**Consultation Response from KC,
Lead Local Flood Authority**

2024/92281 Land adj, 17, Whitehall Road West, Birkenshaw, BD11 2LS

Erection of 23 dwellings

Date Responded: 22nd October 2024

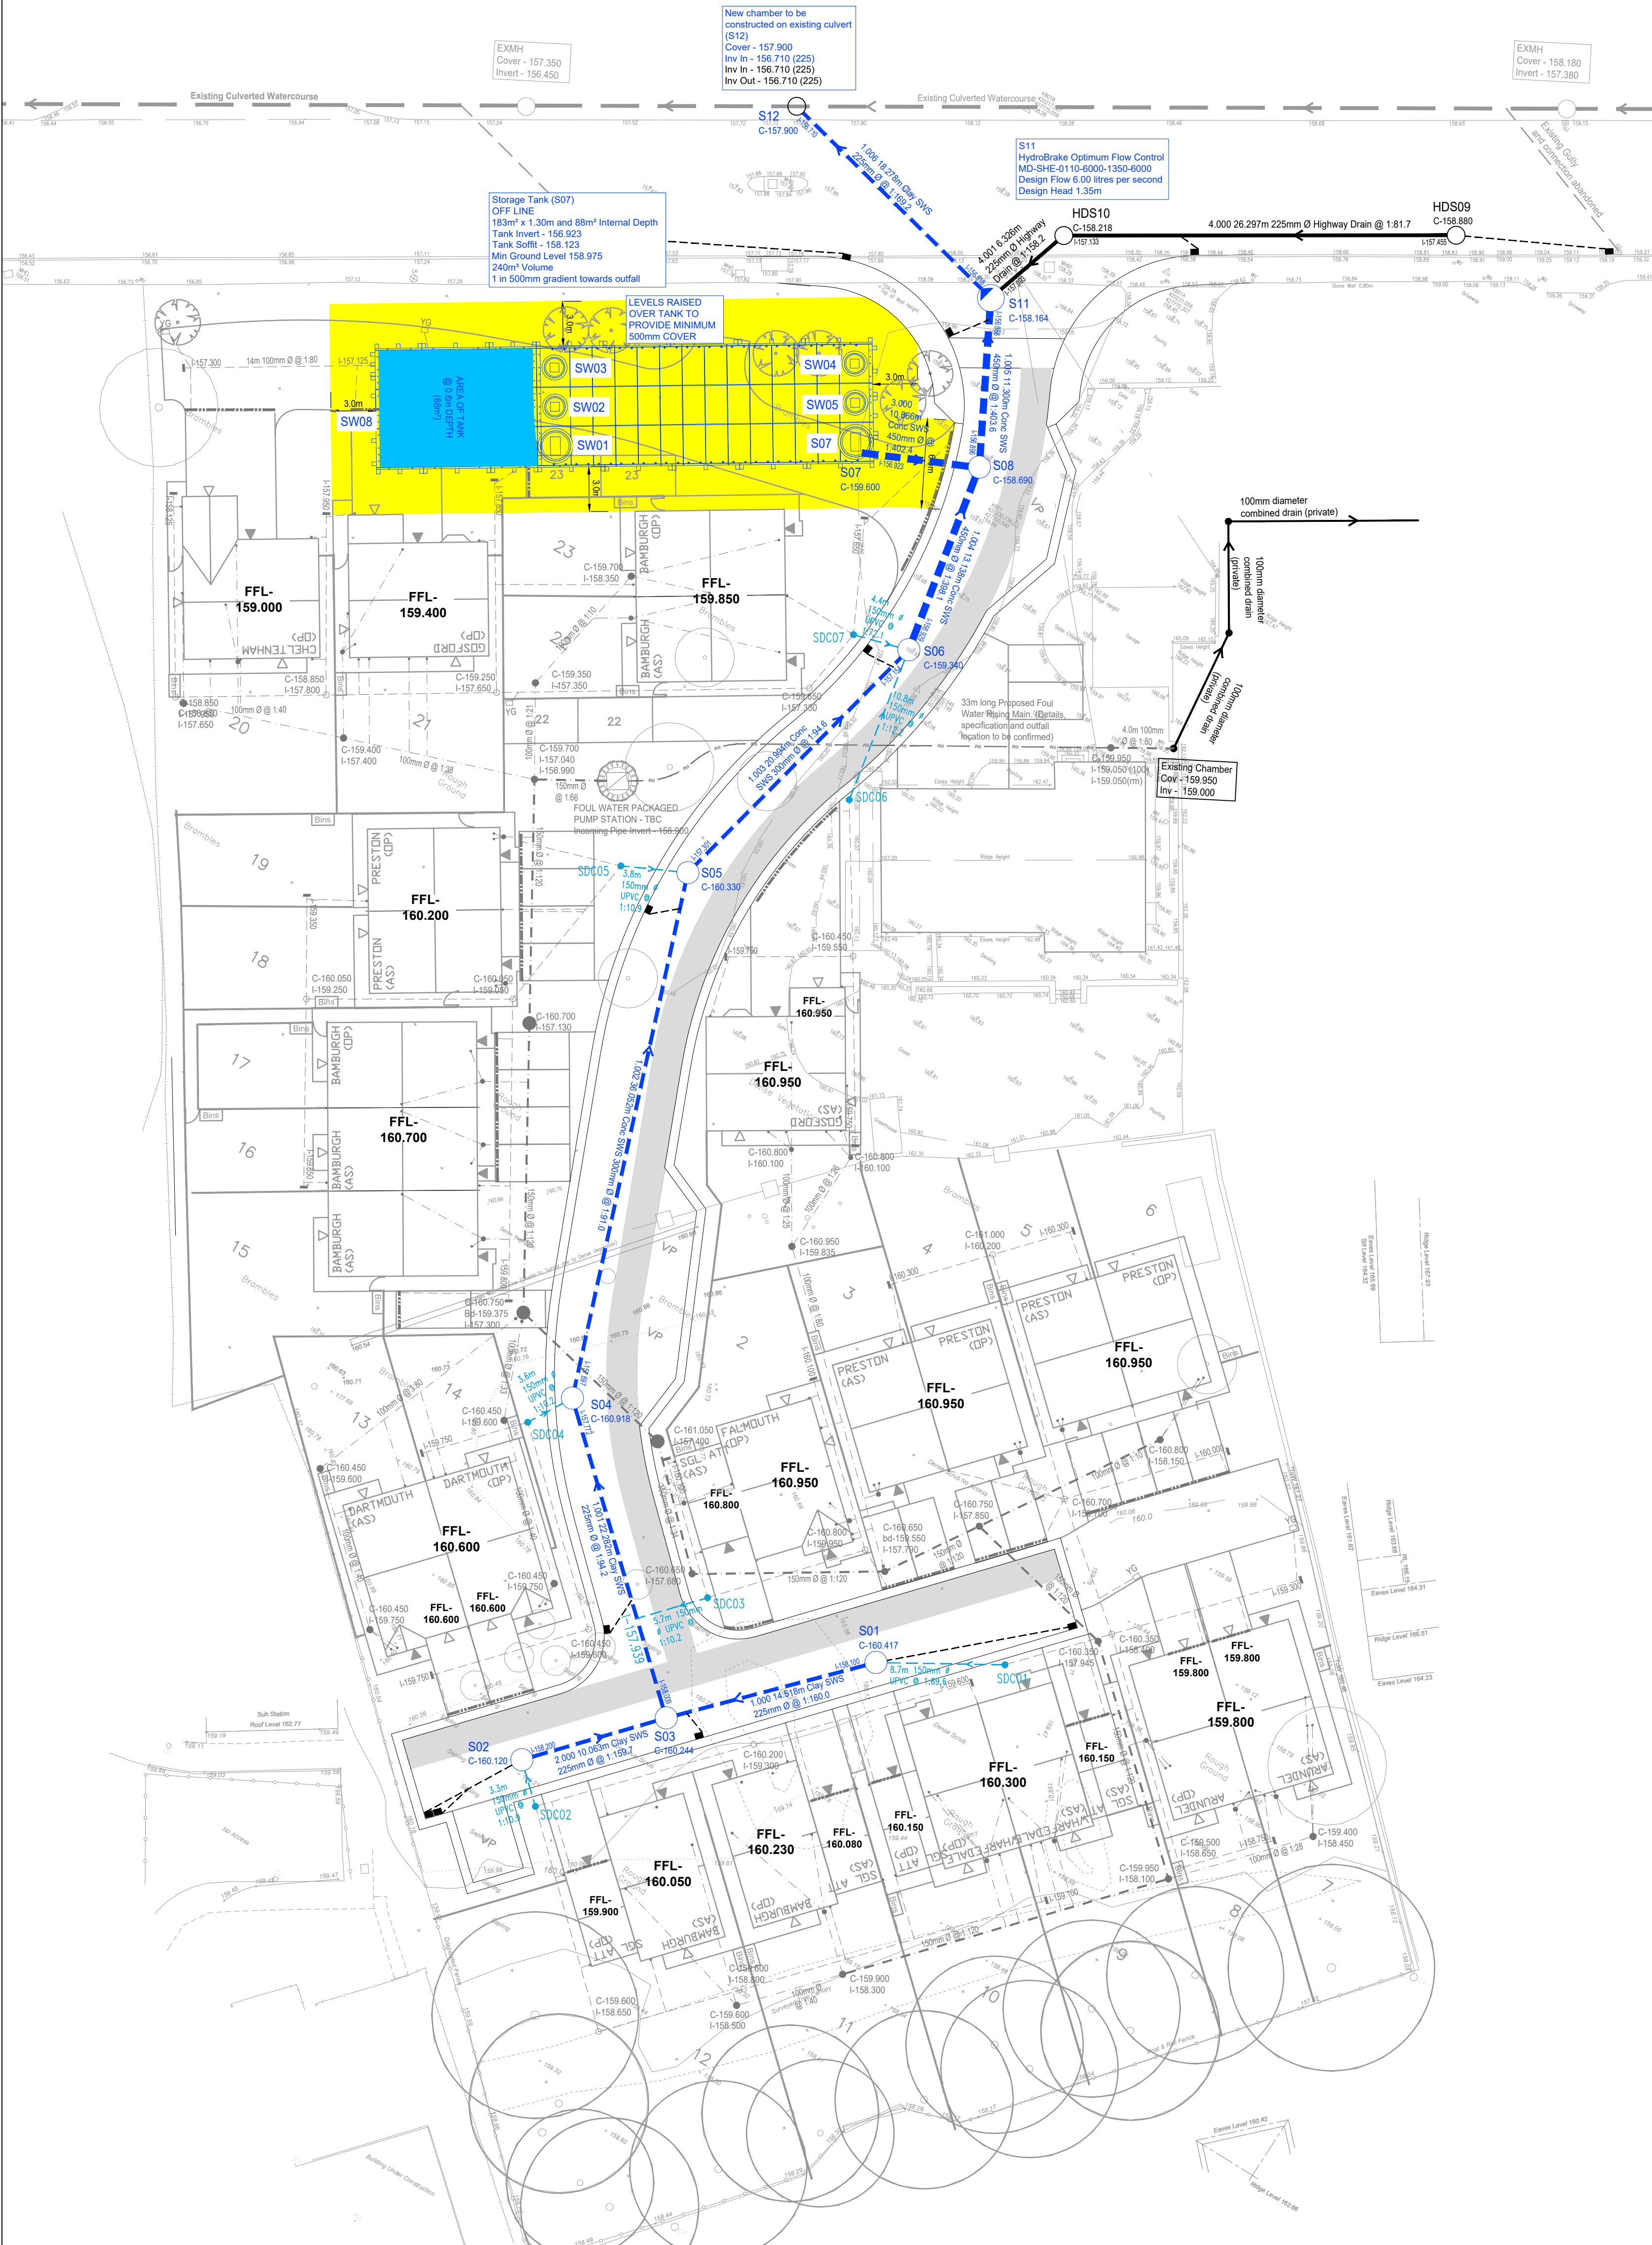
There appears to be confusion regarding the submissions since our last commentary. Two different layouts are submitted with the flood routing plan and the drainage layout.

In addition, flooding is shown on the simulation which is unacceptable. We also need the inputs for drainage areas associated with the simulation. This must clearly identify the external road's contributions to the attenuation design
